City of Albuquerque Stormwater Construction Site Inspection Report

ESC File No.	C09E012A	Project Name:	Durango Units 3 and 4		
NPDES Id. No.	NMR1003L6	Location:	Woodmont Ave. and Sunlight Peak		
4/20/2021	Owner	Contractor			
Operator	Hakes Brothers				
Contact name & title	Chris Hakes				Mark Asplund
e-mail	chris@hakesbrothers.com				mark.asplund@hakesbrothers.com
Contact Phone #	505-842-1700				505-873-8780
COA Inspector	Thomas Evans		Start/End Time:	1:00 PM/1:30 PM	
Construction Phase:	Vertical				
Type of Inspection:	☒ Regular	☐ Storm Event	☐ Past Storm Event >0.25"	☐ 311/Complaint	☐ Follow Up
Weather at time of inspection?	clear		Temperature:	~ 62	
Estimated date of last storm 0.25" or greater	2/22/2021

ESC-1

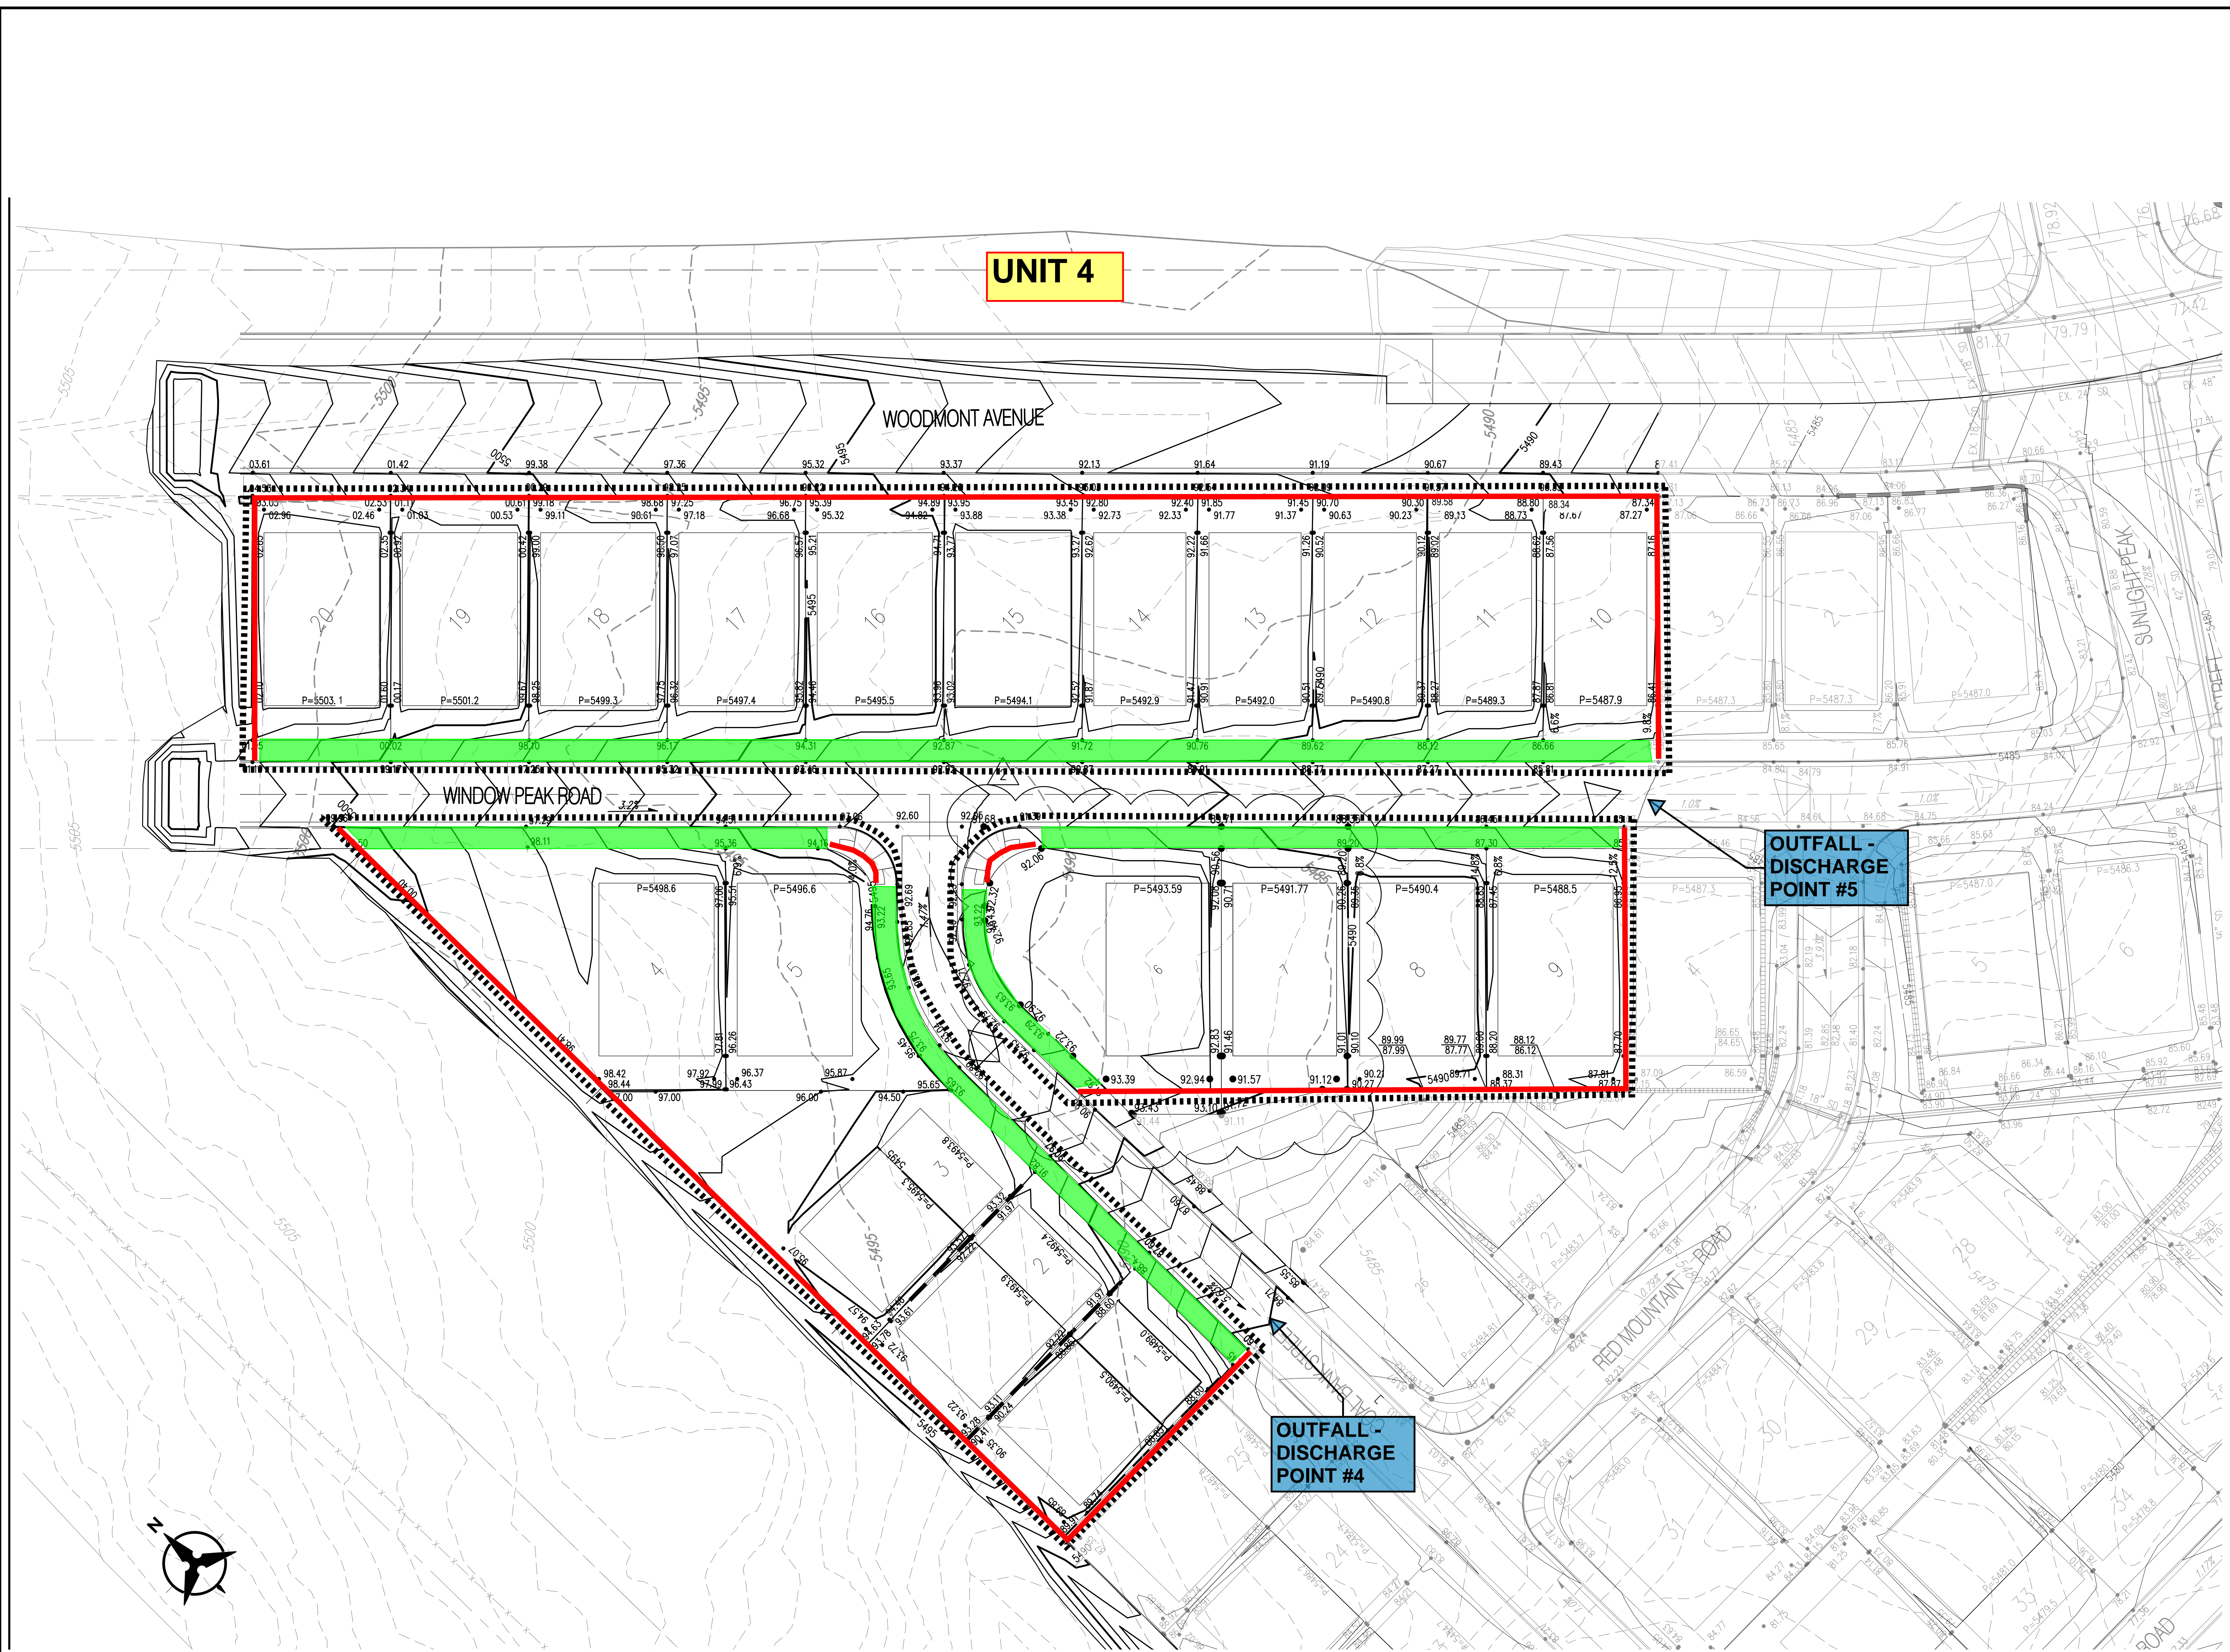
Item Number	Deficiency/ Corrective Action				
1	Install and maintain inlet protection				
2	Use proper containers for construction and domestic waste				
3					
4
